# Comments for Planning Application 21/03596/H

Application Number: 21/03596/H

Address: 9 Westleigh Park Bristol BS14 9TJ

Proposal: Two storey rear extension.

9 WLP/SRE/04.

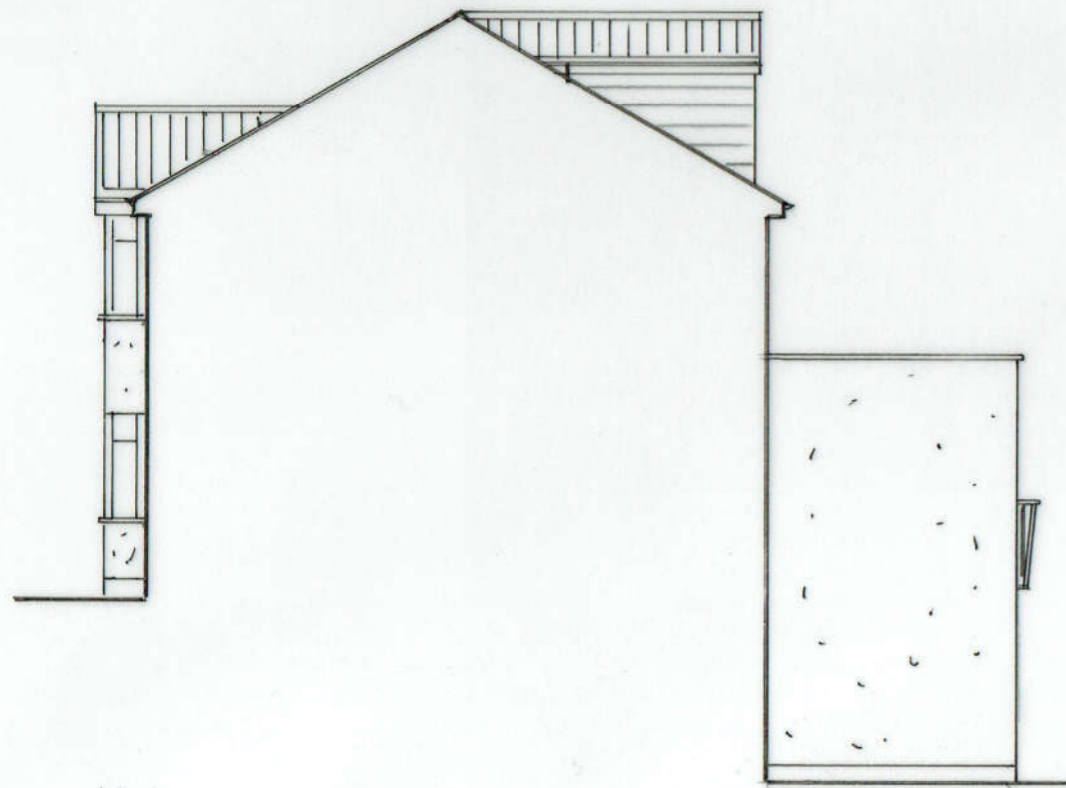
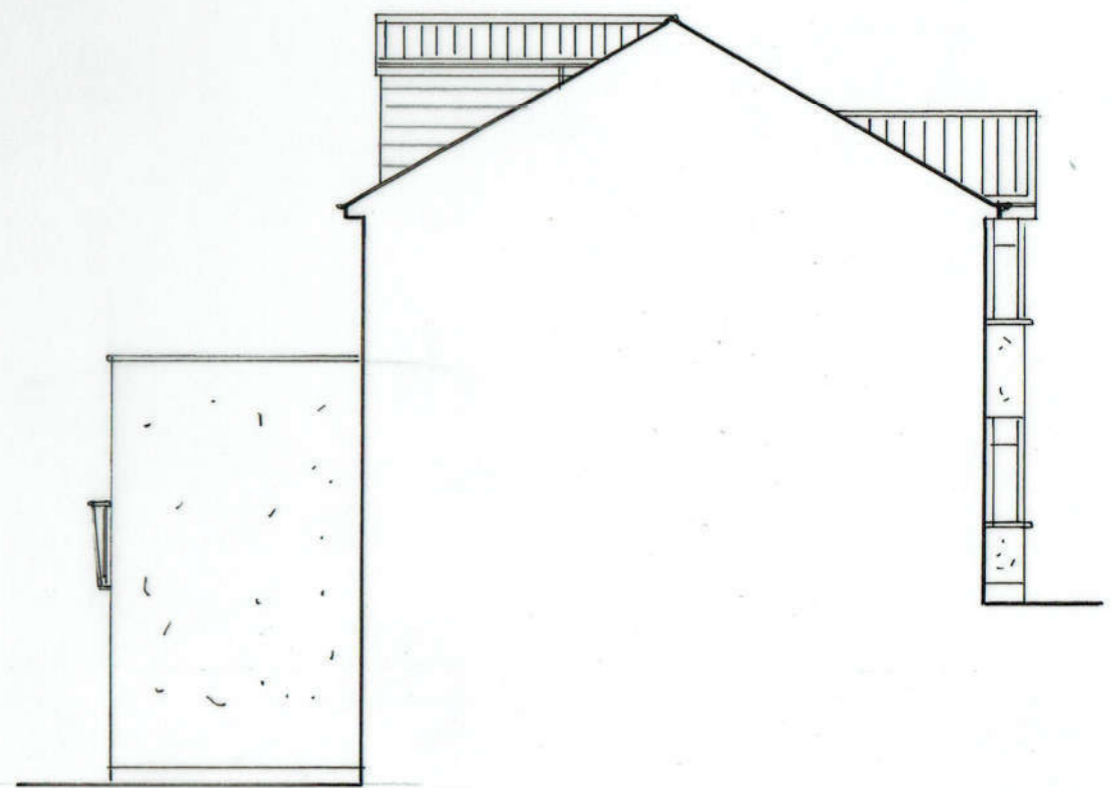
The planning application omits to mention that the proposed basement extension will require a floor level below the existing basement (due to headroom limitations).

As a consequence, the new floor level would be below the existing ground level and will necessitate a considerable amount of excavation adjacent to existing buildings (Nos. 7, 9 & 11 Westleigh Park).

The full extent of any proposed excavation should be clearly stated.
